Recommendation Report for Planning Permission for Works or Extension to a Dwelling

REF NO: BN/82/19/HH

LOCATION: Sunny Side Barn
Yapton Road
Barnham
PO22 0AZ

PROPOSAL: 2 No. rooflights in south elevation.

Proposed roof 1:100

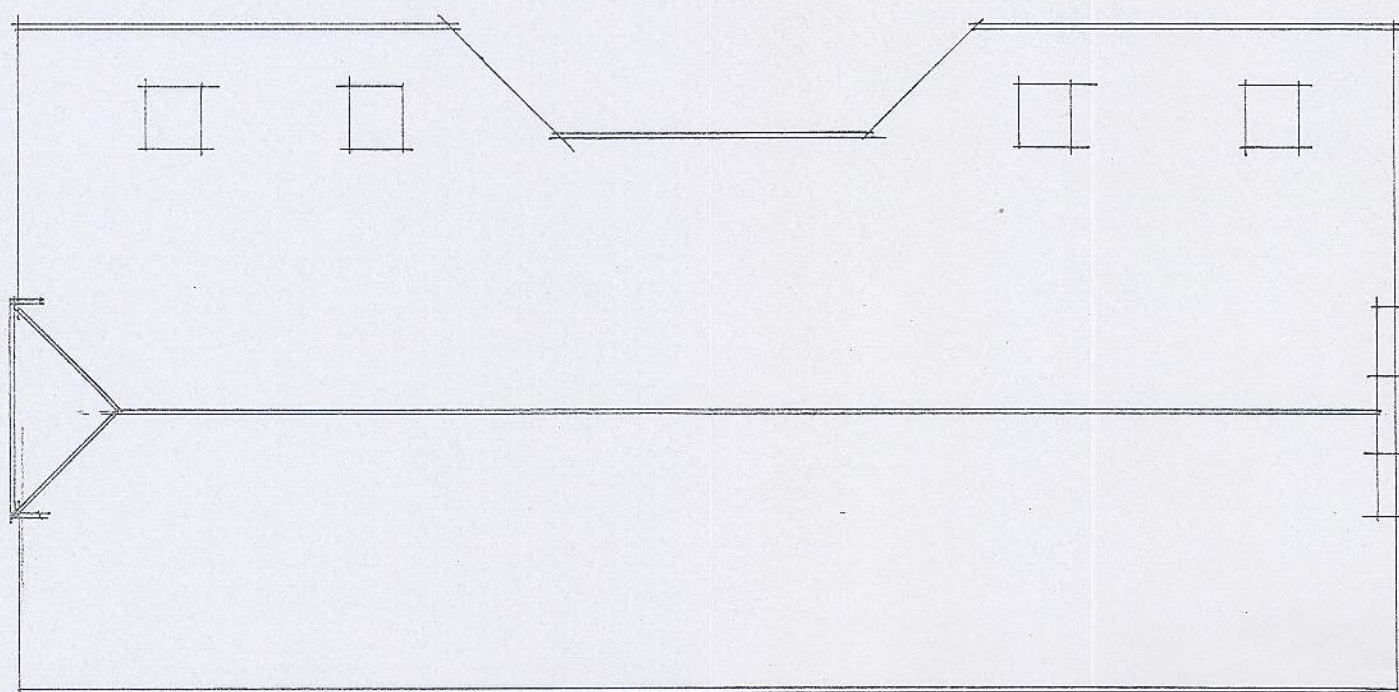
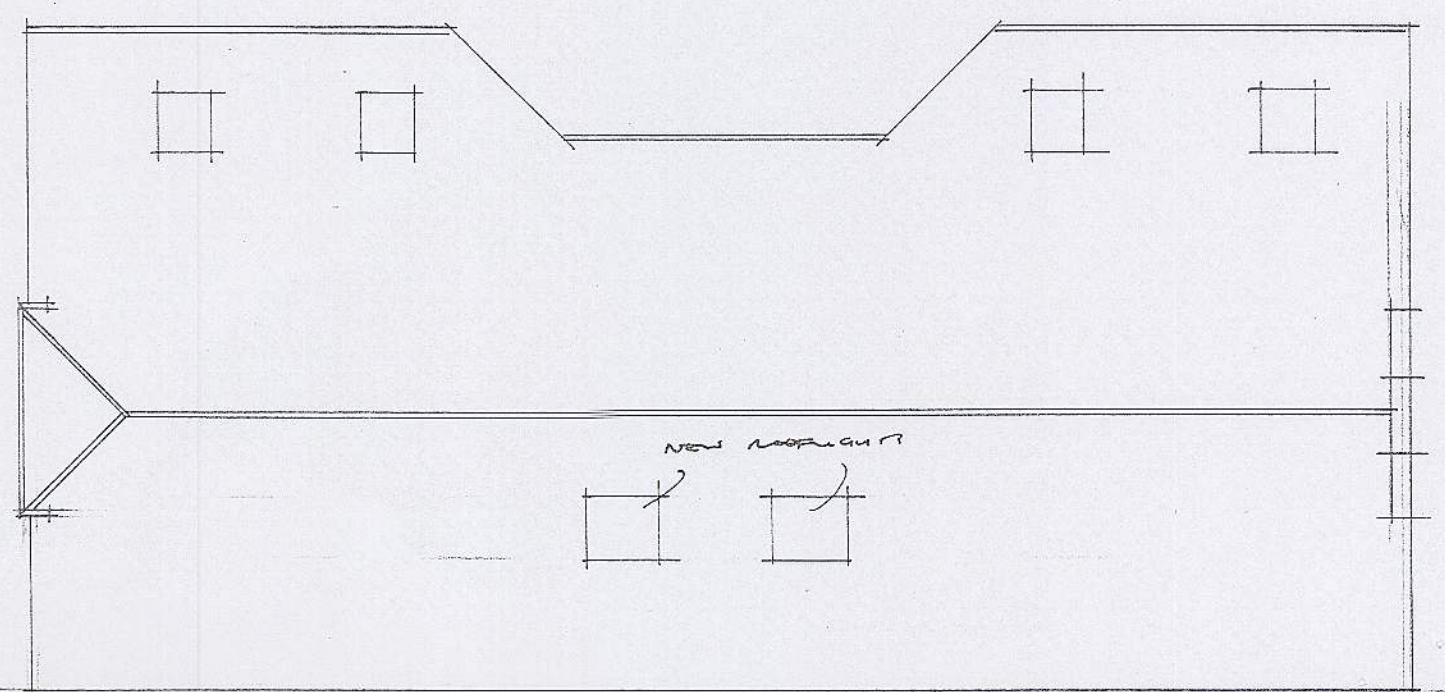
The proposed windows are located at the rear of the property. There will be two additional Velux that are relatively small in size. situated at the centre of the roof. Due to the modest sizing and placement of the windows, it is not considered that the proposal would not affect the character of the surrounding area.

Proposed South 1:100

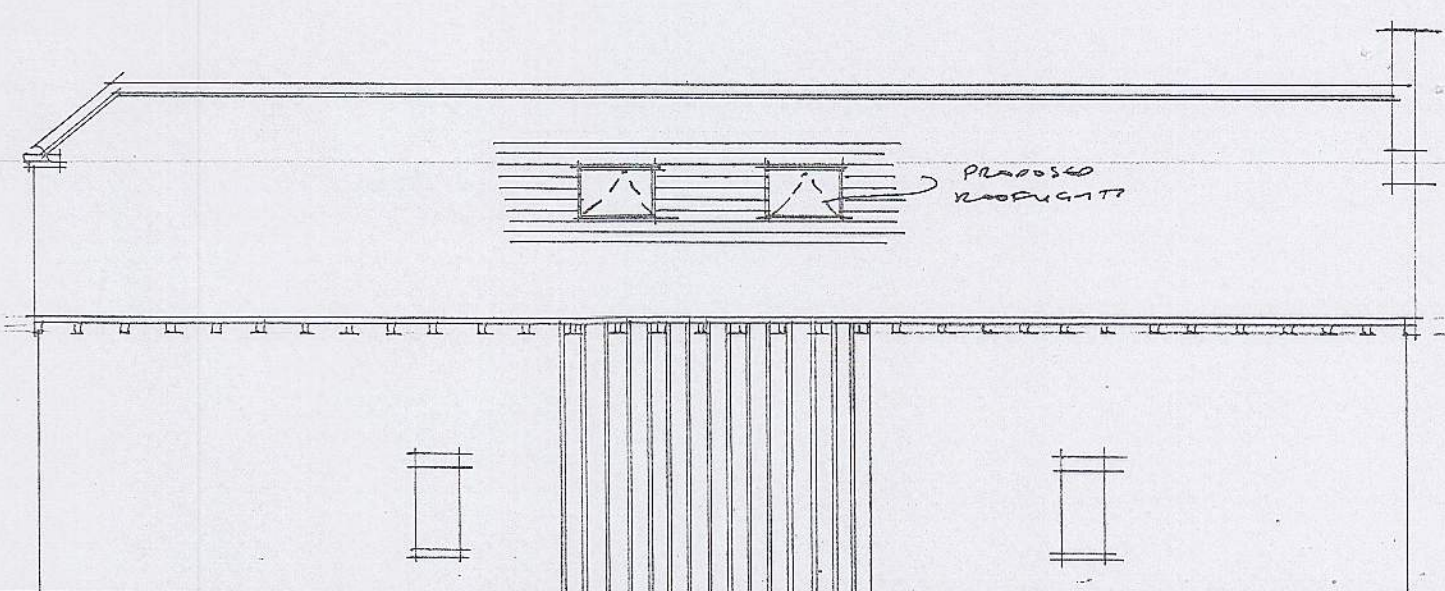
The proposed windows face towards the principal elevations of the neighbouring property (Chestnuts). However, due to their height being 1.5m and the fact that both units are over the stairs or stair well, it is deemed that there would be no adverse overlooking.
